| Our ref: | 24/00757/FULL | Tel No: | |

Address: 8-10 Grosvenor Gardens, London, SW1W 0DH,

Proposal: Installation of emergency lighting to the rear escape staircase (Linked to 24/00758/LBC).

Title  
Proposed Second Floor Plan

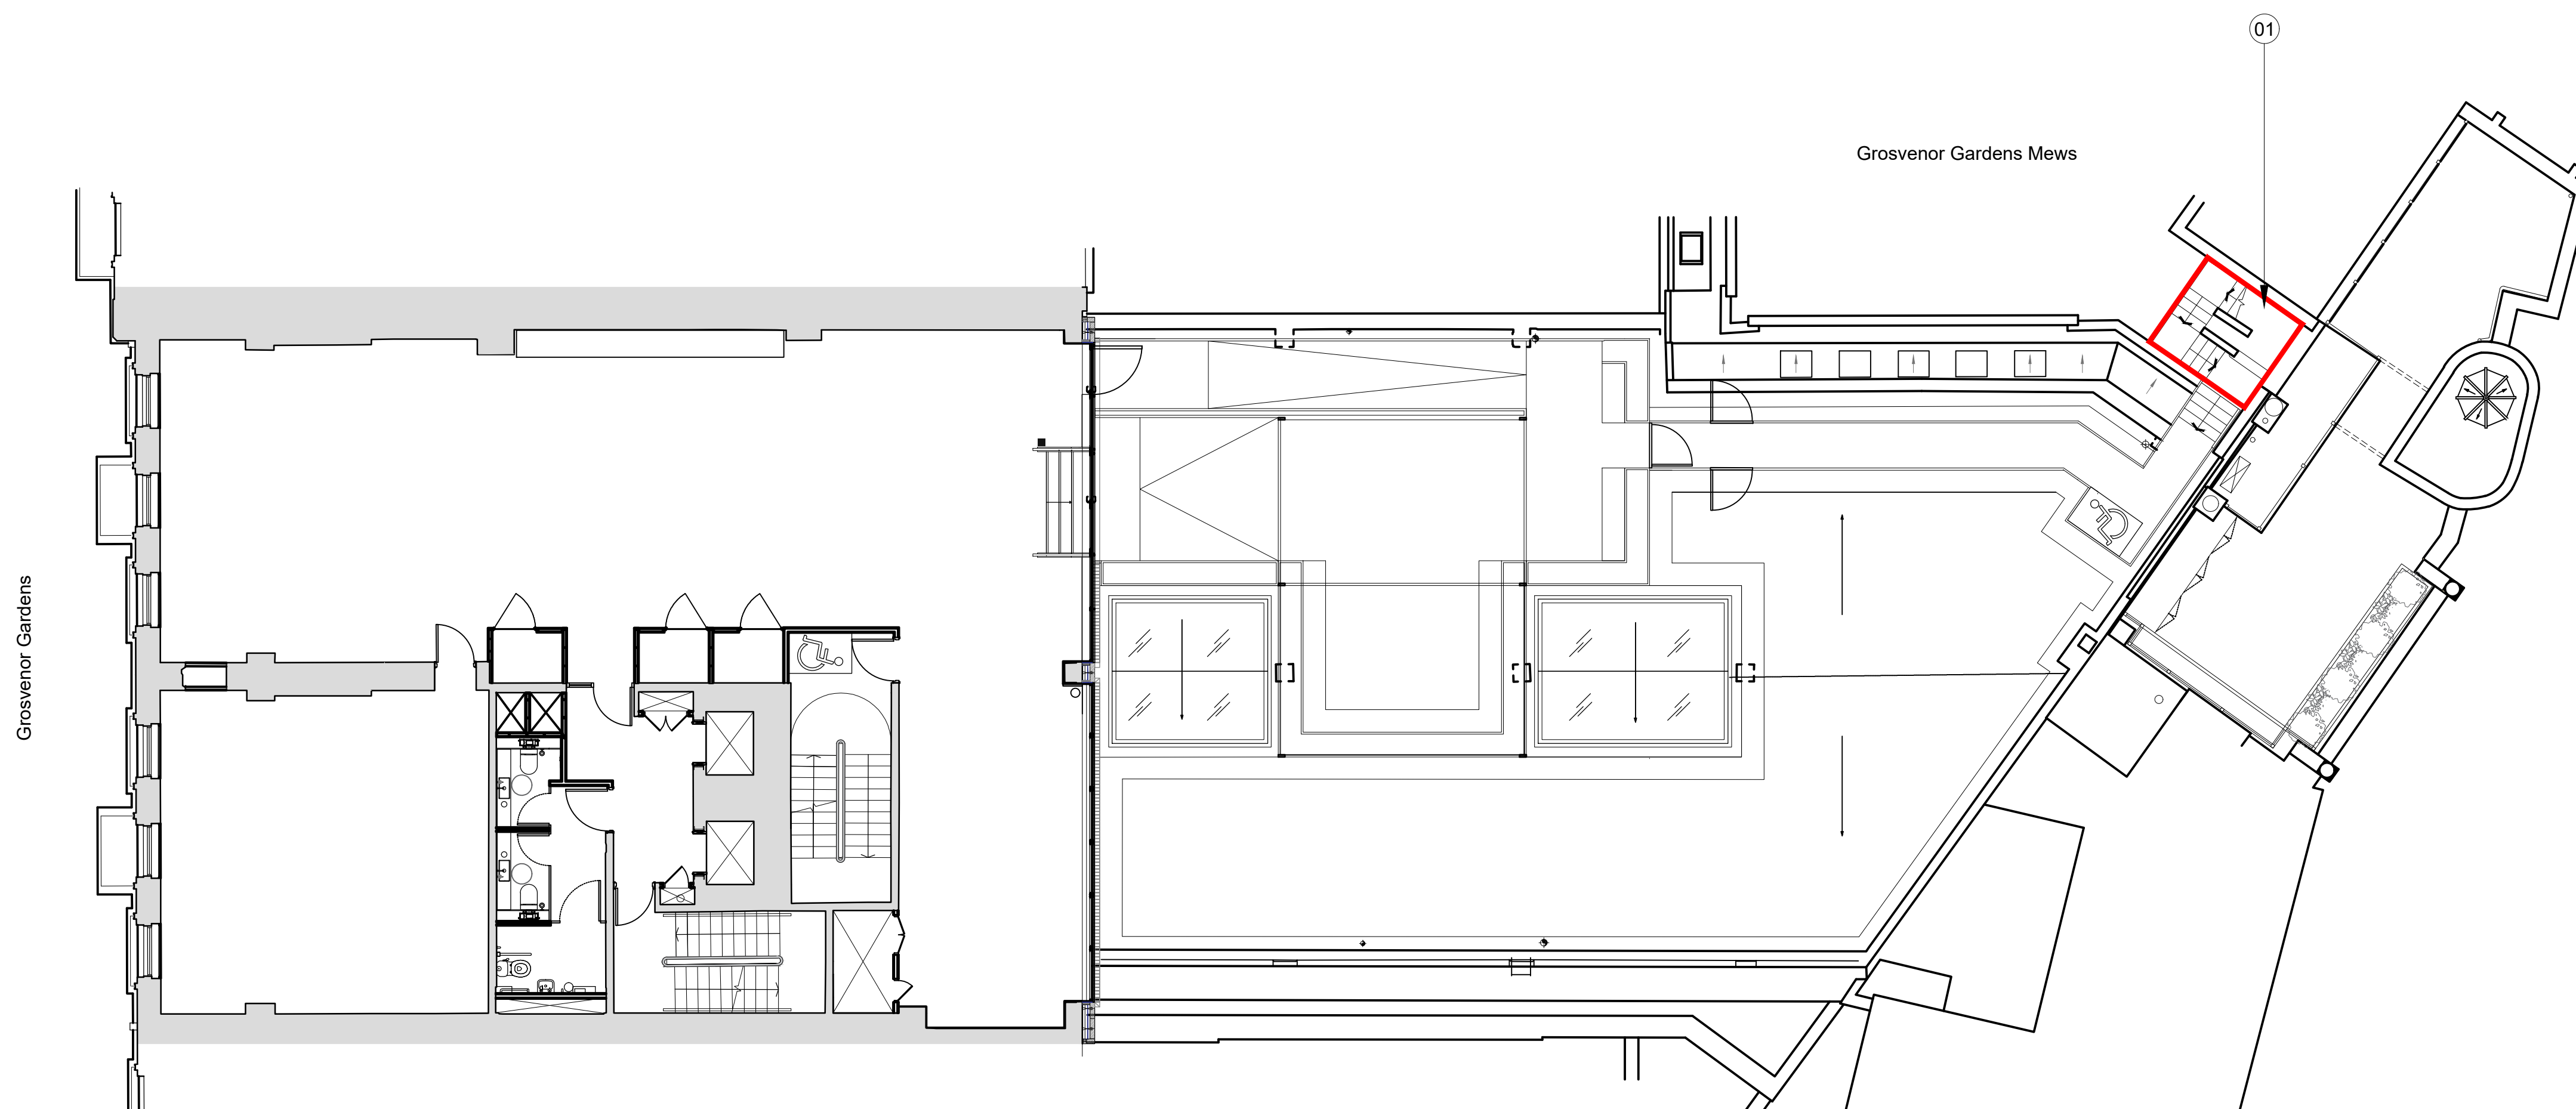
2. Please provide a plan that identifies the location of the escape staircase in context with the entire application site/building.

Title
Site Location Plan

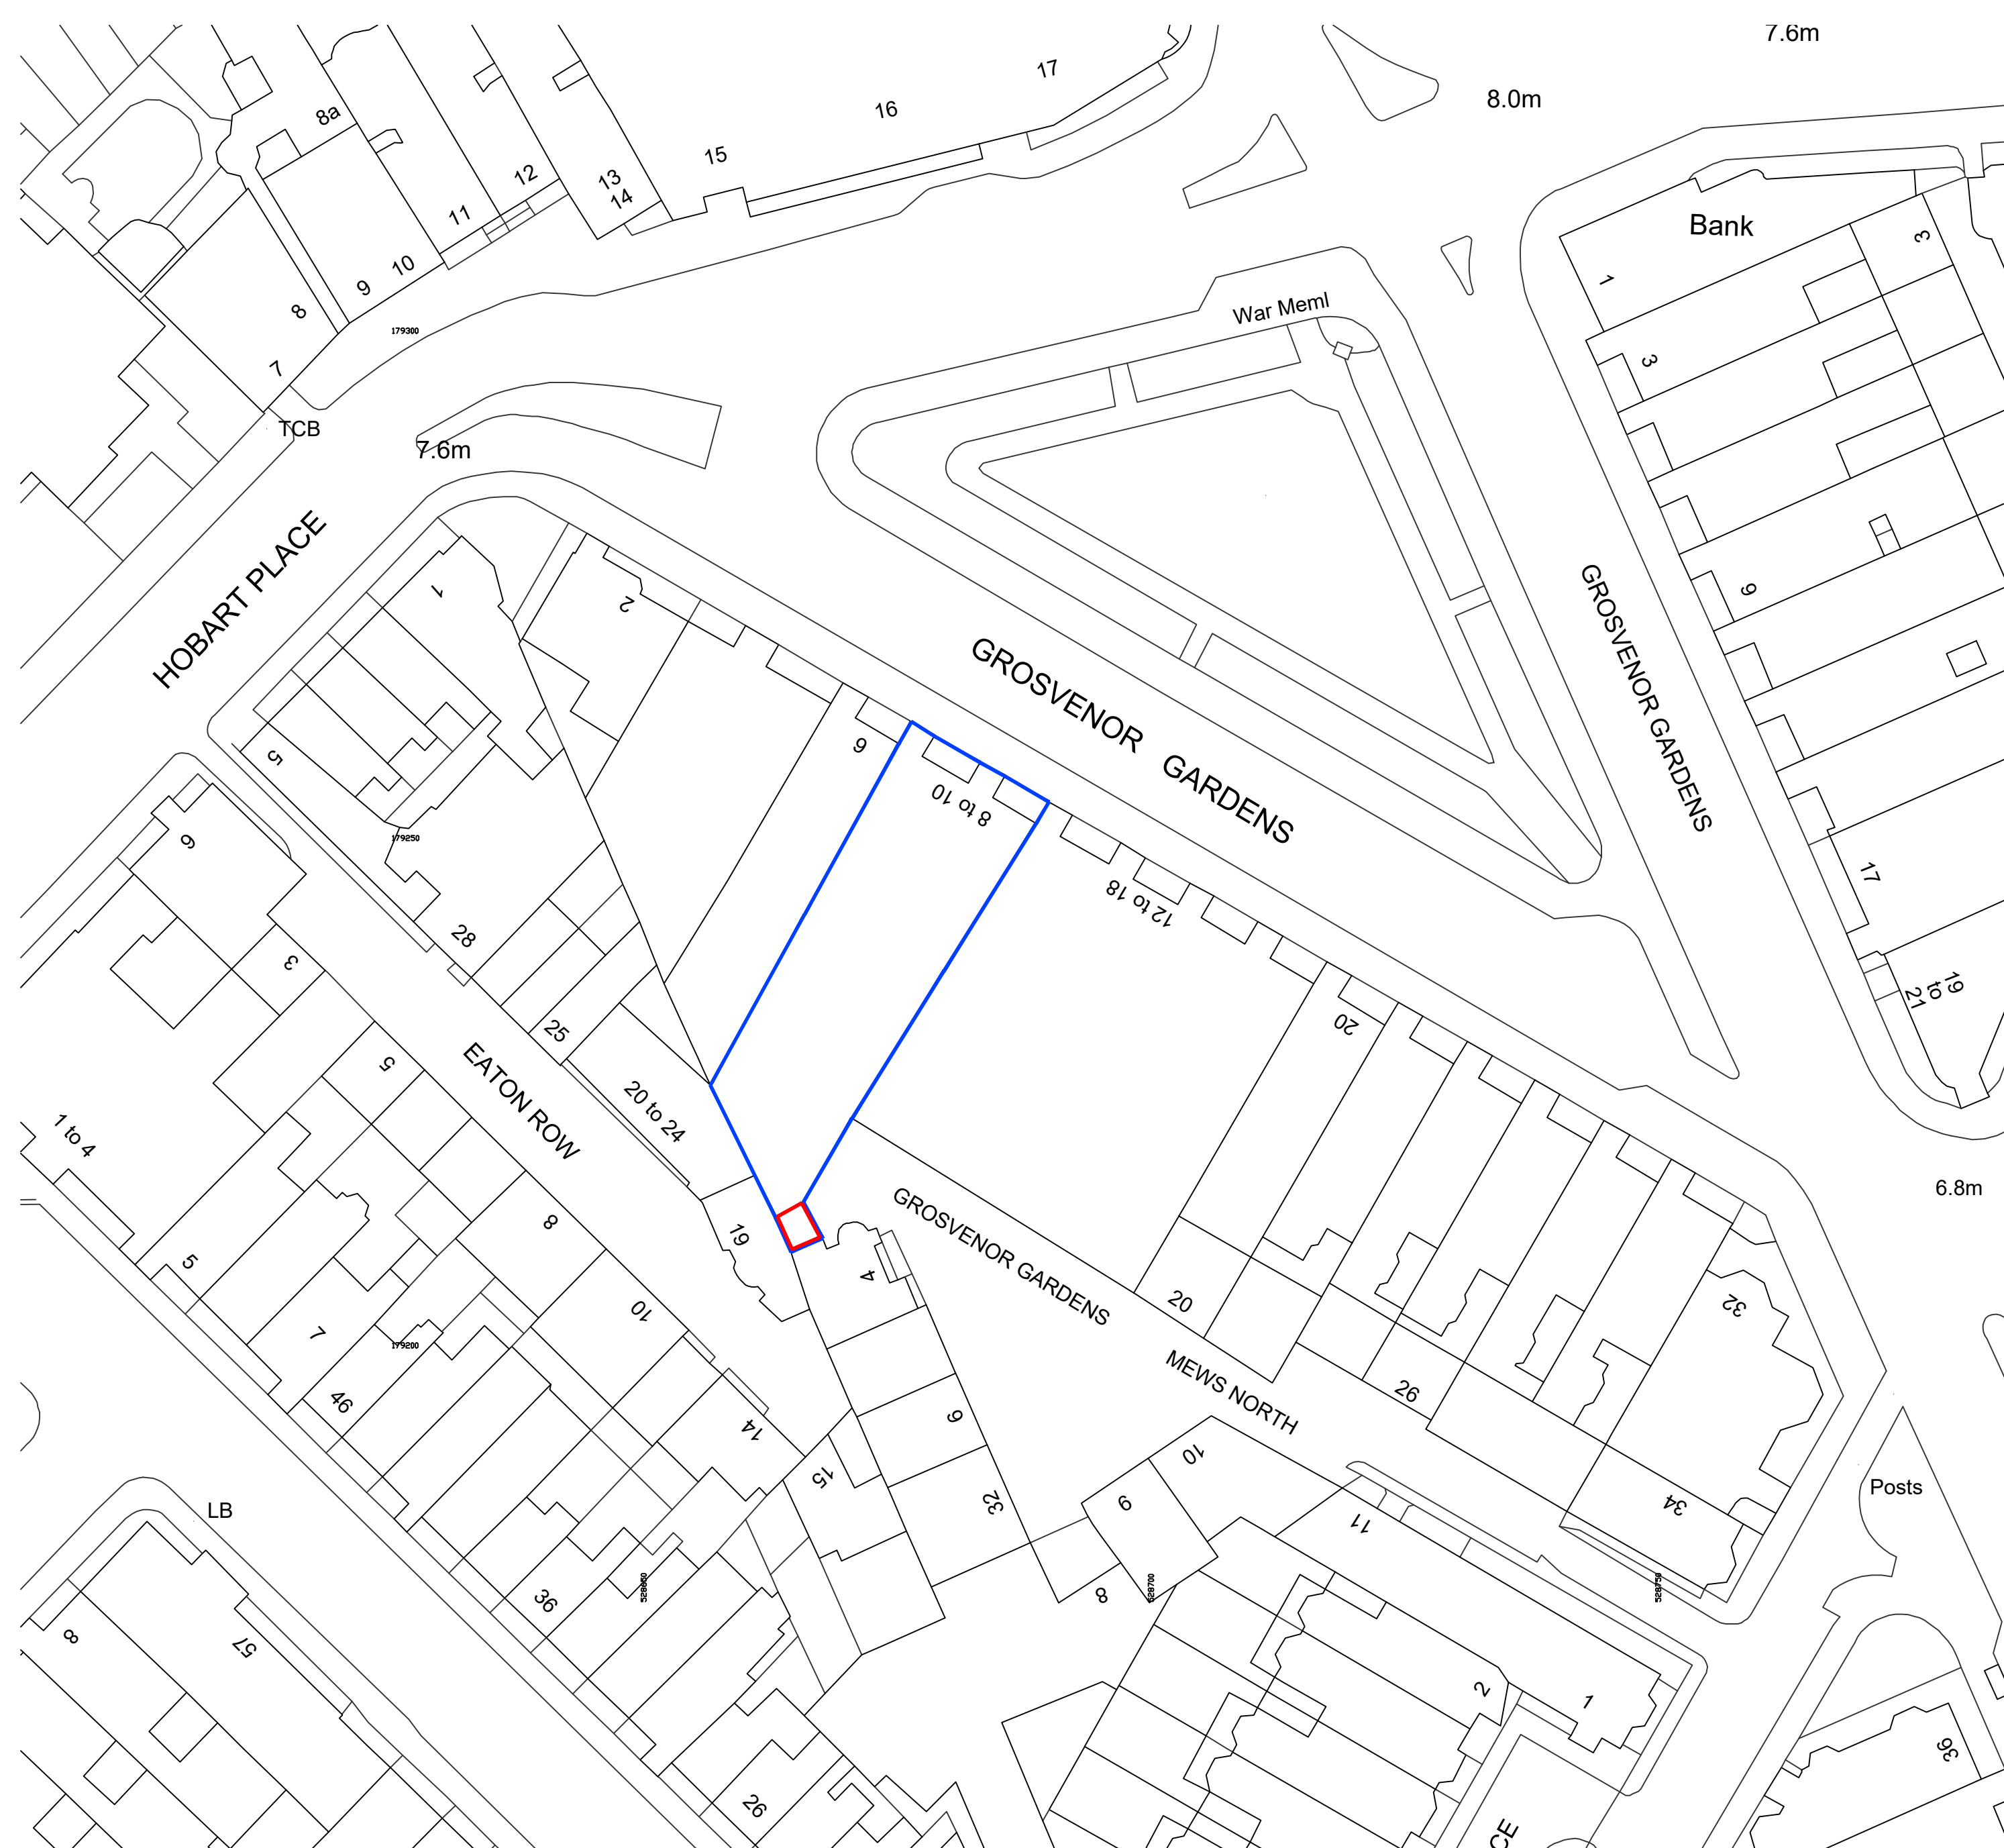
1. The location plan submitted with your application does not identify the entire site/application building. Please provide a location plan based on an up-to-date map at a scale of 1:1250 which shows the direction of north and clearly shows the entire site outlined in red and any other land in the same ownership outlined in blue.
